February 5, 2008

RE: Casco Bay Ventures, 130 Promenade East

RE: Casco Bay Ventures, 130 Promenade East

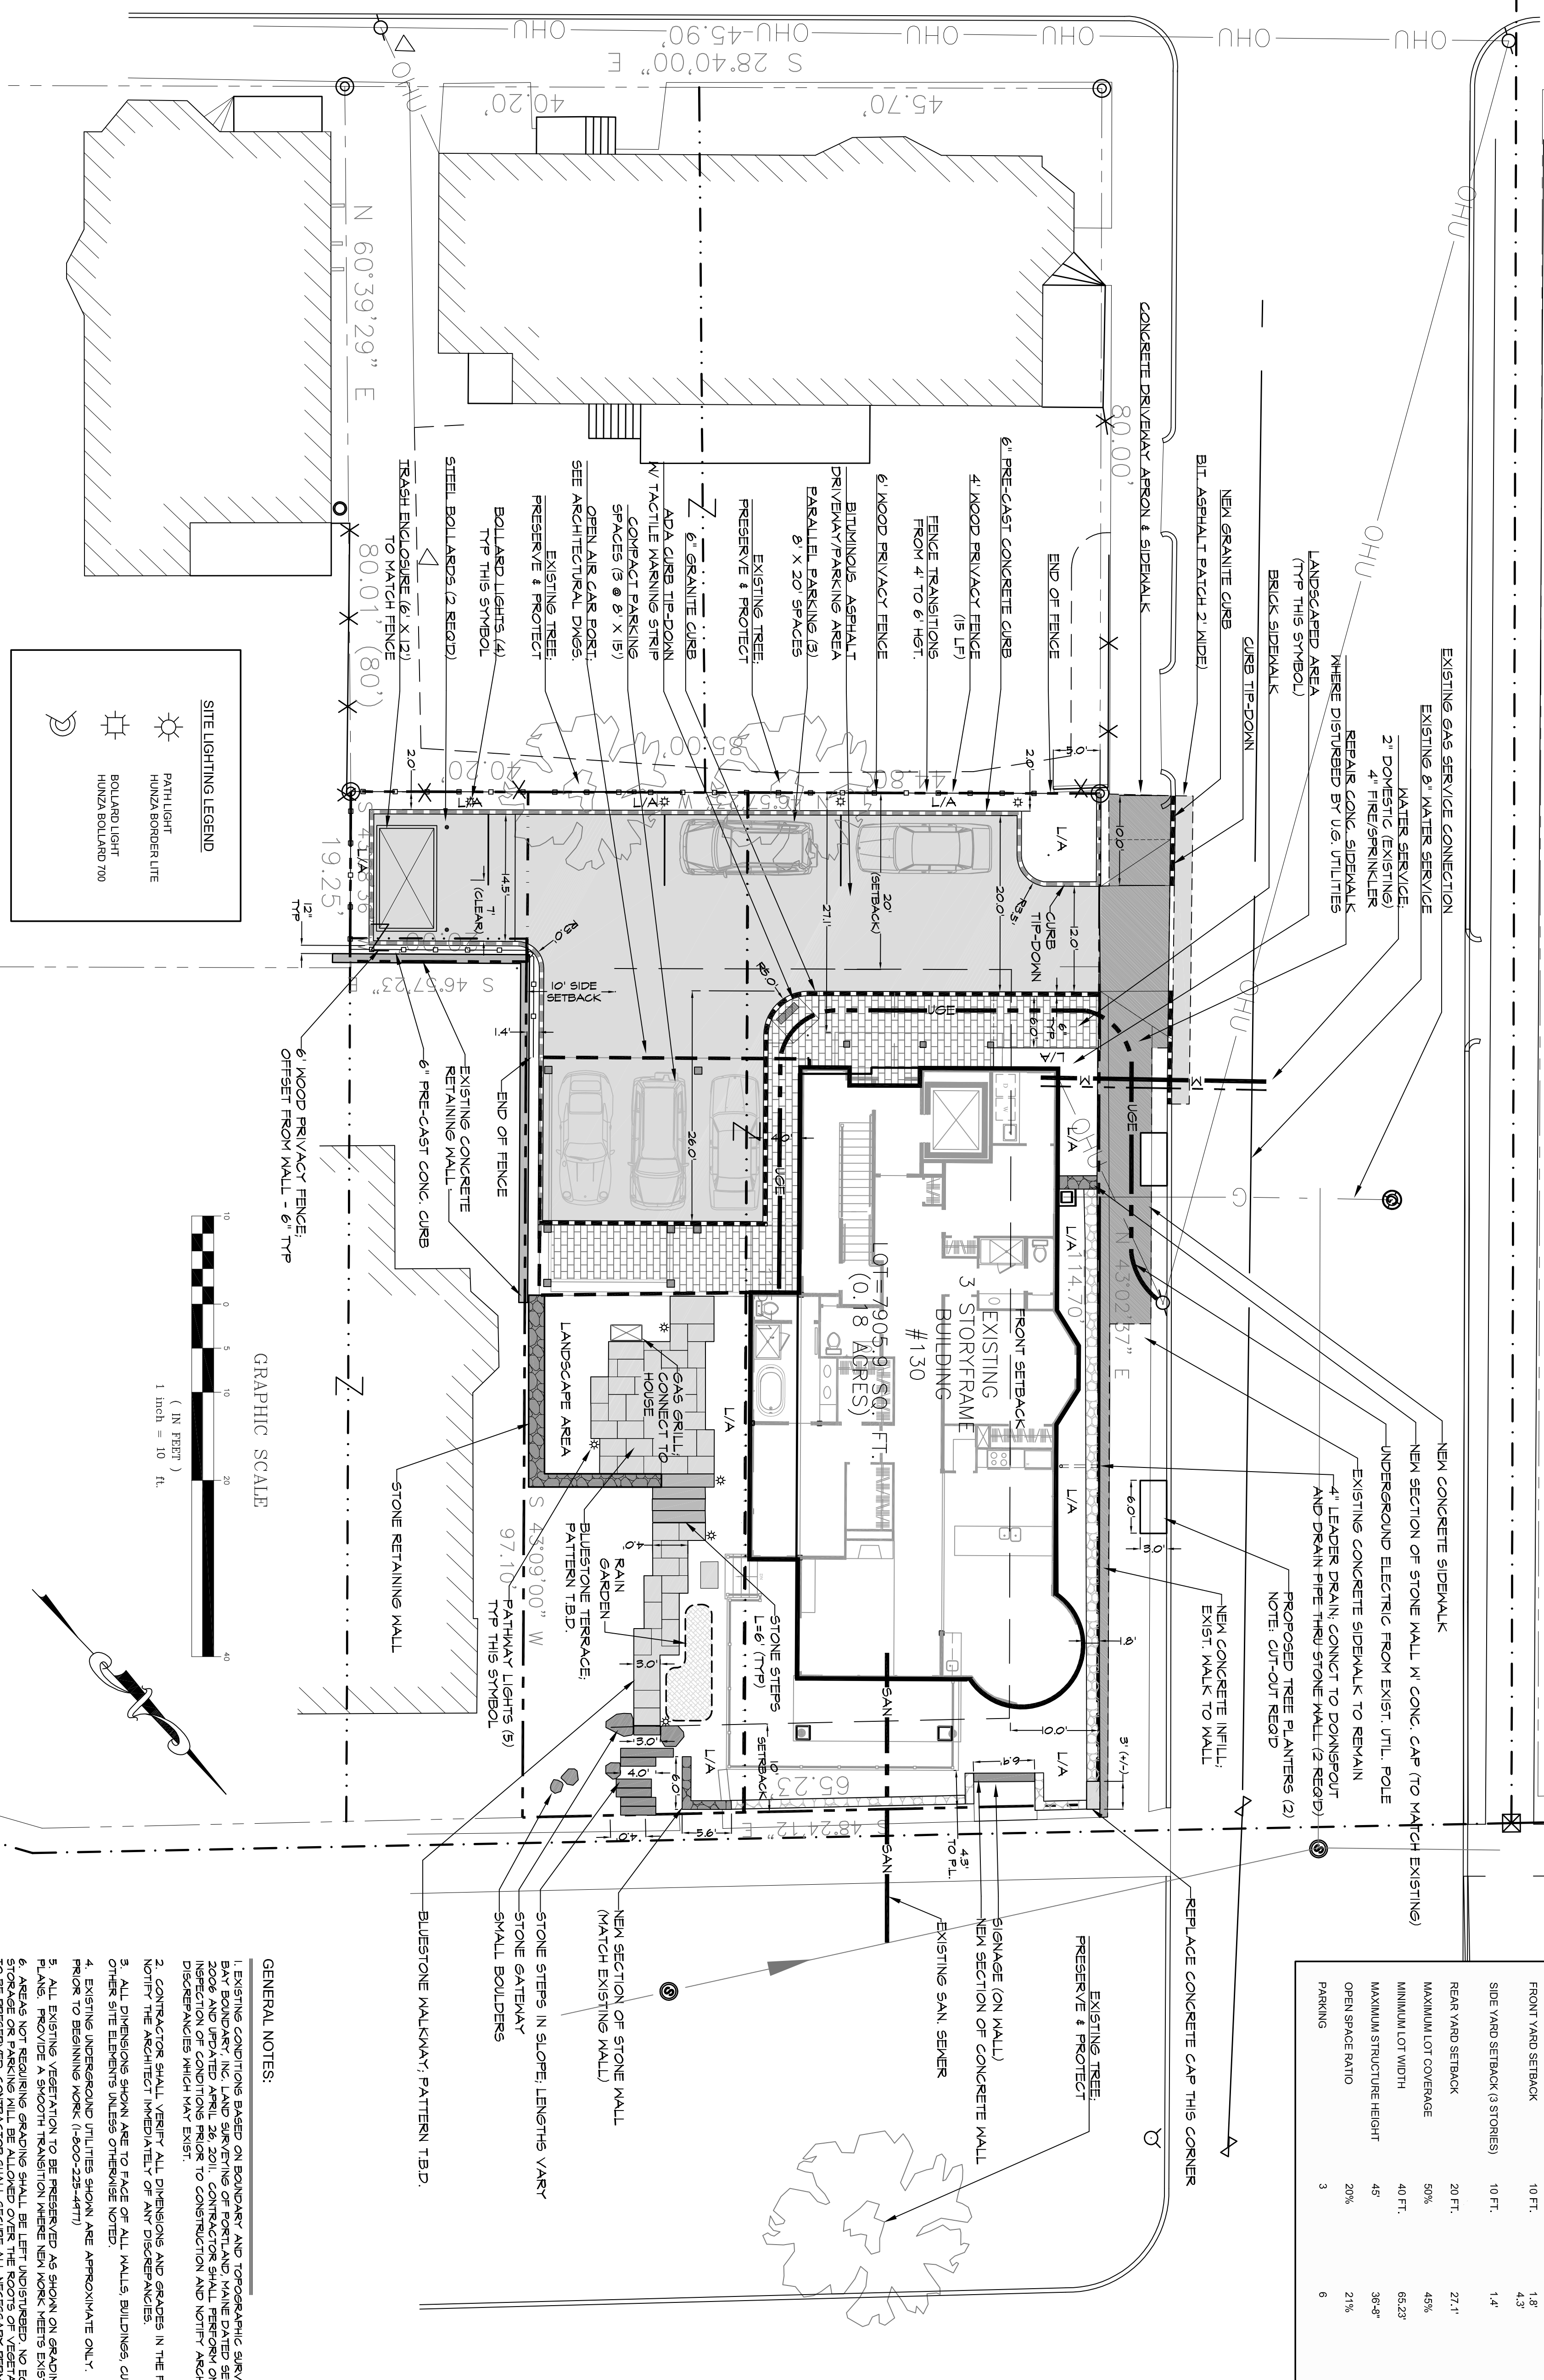
Thank you for providing a copy of the attached site plan showing green shaded sections representing what Casco Bay Ventures considers to be "open space." I understand that this document was submitted by Casco Bay Ventures to Ms. Schmuckal for purposes of satisfying the open space requirements of the Land Use Ordinance. I note that the document is not full size and does not explain how the square footage of the area was measured. I had the area measured using a computer assisted design software program at 1,485.26 square feet, which is only 18.8% of the site area. See the enclosed computer print-out. This is clearly insufficient to satisfy the open space requirement found in §14-139(1)(h).

Even if the applicant can demonstrate that their 20.48% measurement is reliable, it should be found insufficient. First, it should be reduced because it includes the trash bin area. Second, it should be rejected because it relies on skinny strips of area that cannot possibly be considered either "open" or "space" in any meaningful or functional sense of those words. When the 20% rule for the R-6 Zone is read together with the site plan standards for open space, it is clear that the concept of "open space" has a functional component to it that cannot be satisfied by a collection of meaningless strips that have no function or use. Section 14-526(a)(15)(a)(1)(b)(3) states that open space "shall be integrated into the development site . . . shall be designed to compliment and enhance the building form and development proposed on the site. Open space functions may include,

but are not limited to, buffers and screening from streets and neighboring property, yard space, etc." These strips have not been meaningfully integrated into the site plan design. They are scraps leftover from the design of a massive structure that is clearly oversized for the site.

Molly Casto, Planner with Portland's Department of Planning and Development, received your letter dated February 1, 2008 regarding Ms. Marge Schmuckal's (Zoning Administrator) determination that the above project meets the open space requirement of the R-6 zone. In the letter, you argue that the plan does not meet the applicable open space ratio.

I have received a copy of the calculations for the open space ratio for this project. The project is meeting the minimum requirements for open space in the R-6 zone.
